N-T9009.00 20101122 JL RFI Response

**PROPOSED 12 LOT SUBDIVISION
LOT 4 DP876253
WILLOW AVE, BOGANGAR
RFI RESPONSE**

KENMAR FARMS PTY LTD
ENGINEERING IMPACT ASSESSMENT

REVISED STORMWATER MANAGEMENT PLAN
OPUS QANTEC McWILLIAM

REVISED STORMWATER MANAGEMENT PLAN
OPUS QANTEC McWILLIAM

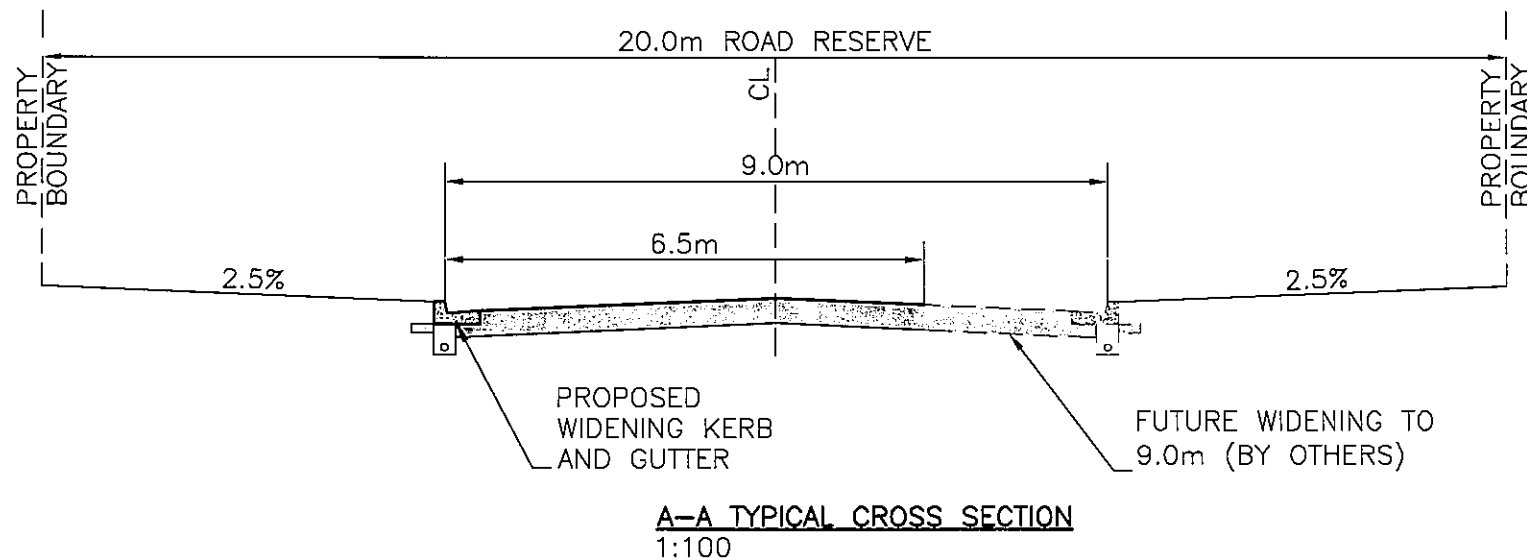
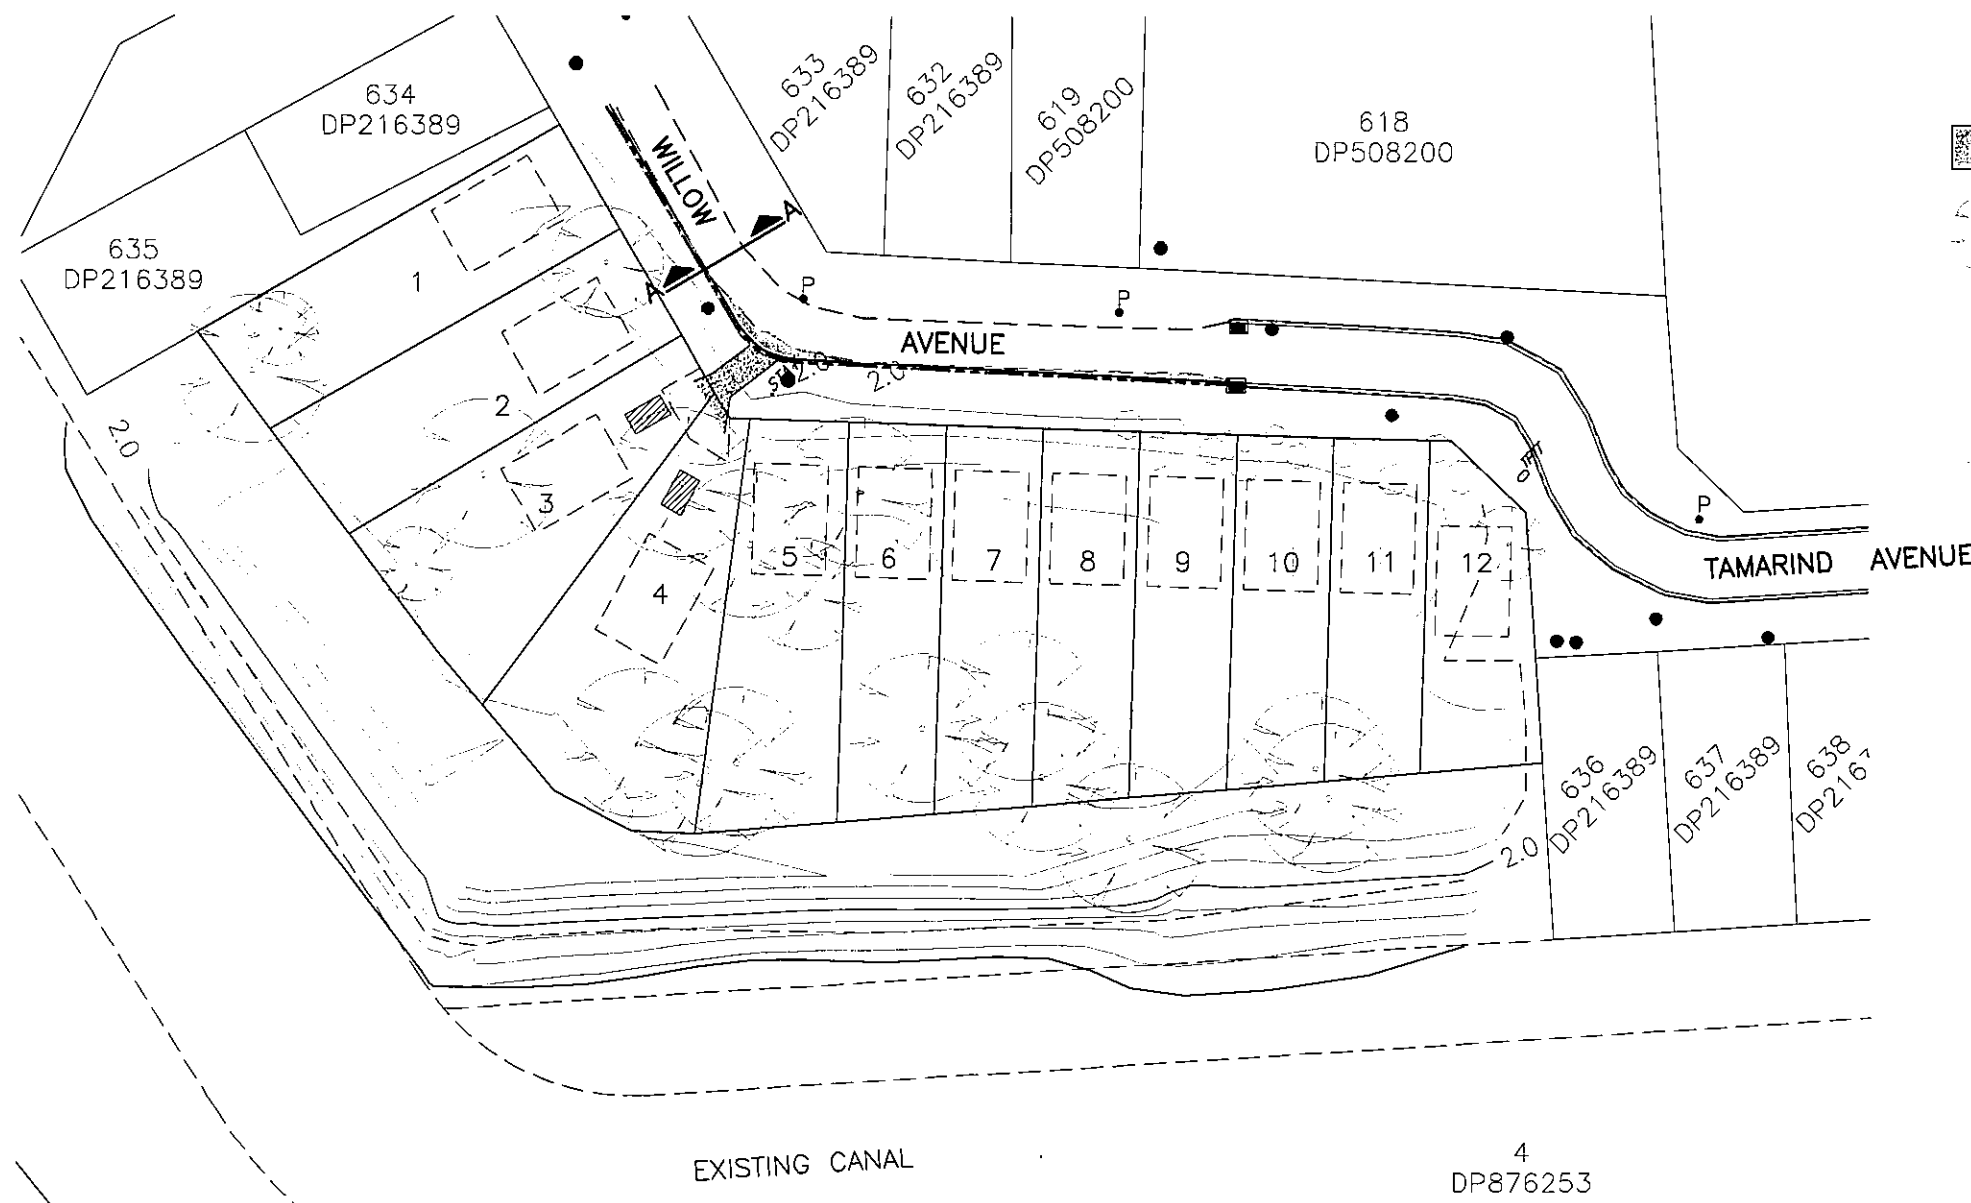
- 2a) The proposed surcharge flows from the infiltration trenches to the rear of the property will discharge overland through proposed Lot 12. Lot 12 is proposed to be a drainage easement and therefore a lawful point of discharge.

- 2b & 2c) Stormwater drainage is addressed by providing roofwater drainage designs to a Q100 capacity to ensure major flows are discharged to the rear of the site and not Willow Avenue. This is the basis of the calculations in our report and addresses the RFI. The proposed lots will also be regraded where necessary and provided with perimeter drains to limit additional filling and drain the remainder of lots to the rear of the site. The proposed layout is demonstrated in the attached sketch N-T9009.00 SK20101119. Please note house pad and perimeter drain locations are indicative only and are provided to demonstrate the minimum requirement to achieve the proposed drainage outcome.
